Engineers Comments Regarding Surface Water Drainage

Application Reference:	BN/103/25/HH	Reviewer Reference:	ADC/KW
Planning Officer:	Silvie Steiningerova	Date of Review:	02/02/2025
Site Name:	Sundance, Yapton Road		
Application Description:	Side extension to bungalow and internal alterations. Re roofing with standing seam metal roof and additional insulation.		
Assessment Number:	1 of 1

SITE PLAN  
SCALE 1:500

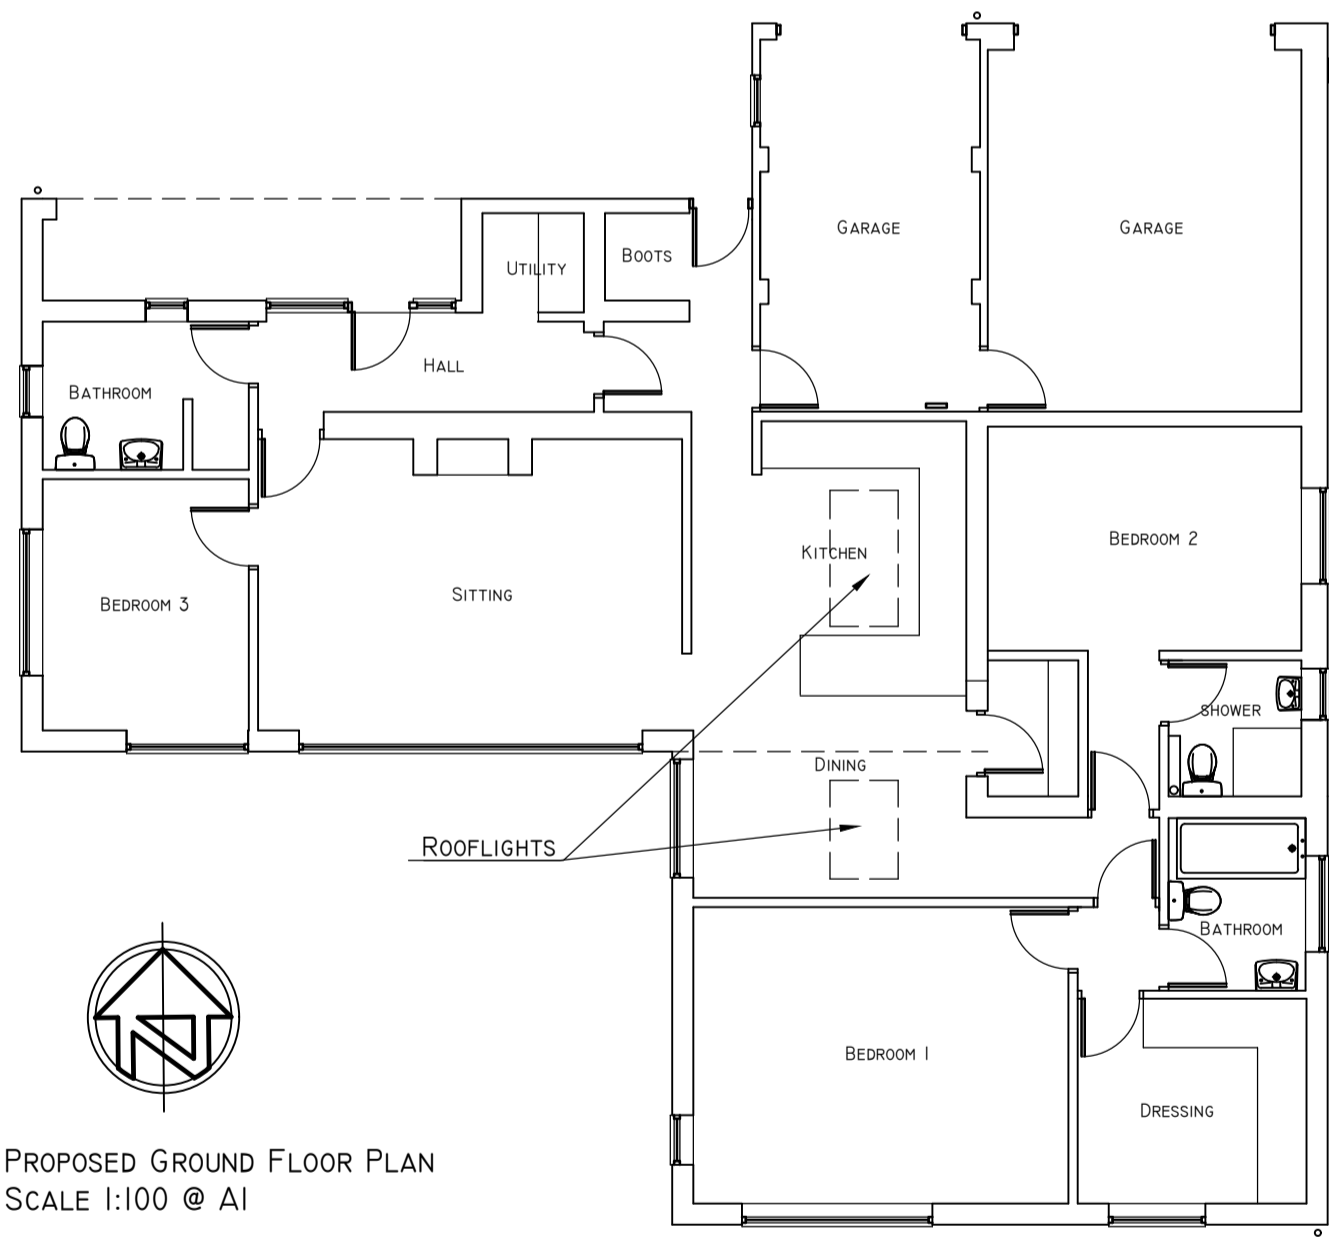
3.1. A small section of surface water flood risk can be found to the rear garden in the south western corner of the site. The design must either account for the volume of water entering the site from elsewhere or ensure that no SuDS features are located within this area and that ground levels are not altered. For further guidance, please refer to our 'SuDS in Flood Areas' document available online at www.arun.gov.uk/surfacewater.

7.1. A significant number of trees can be found surrounding site; this may significantly impact the ability to infiltrate to the ground or discharge to the ordinary water course.

7.2. Insufficient information regarding the construction, operation and maintenance of the SuDS system, and therefore Standard 8 of the Systems NSfS. As a result of the existing trees which could impact the scale and layout and location of SuDS features, as such it is not appropriate to secure details via condition. Accordingly, **we object to the proposal on this ground**, and require the applicant to provide details of existing trees and plans that demonstrate that any SuDS features do not conflict with them to ensure compliance with Standard 8 of the NSfS.
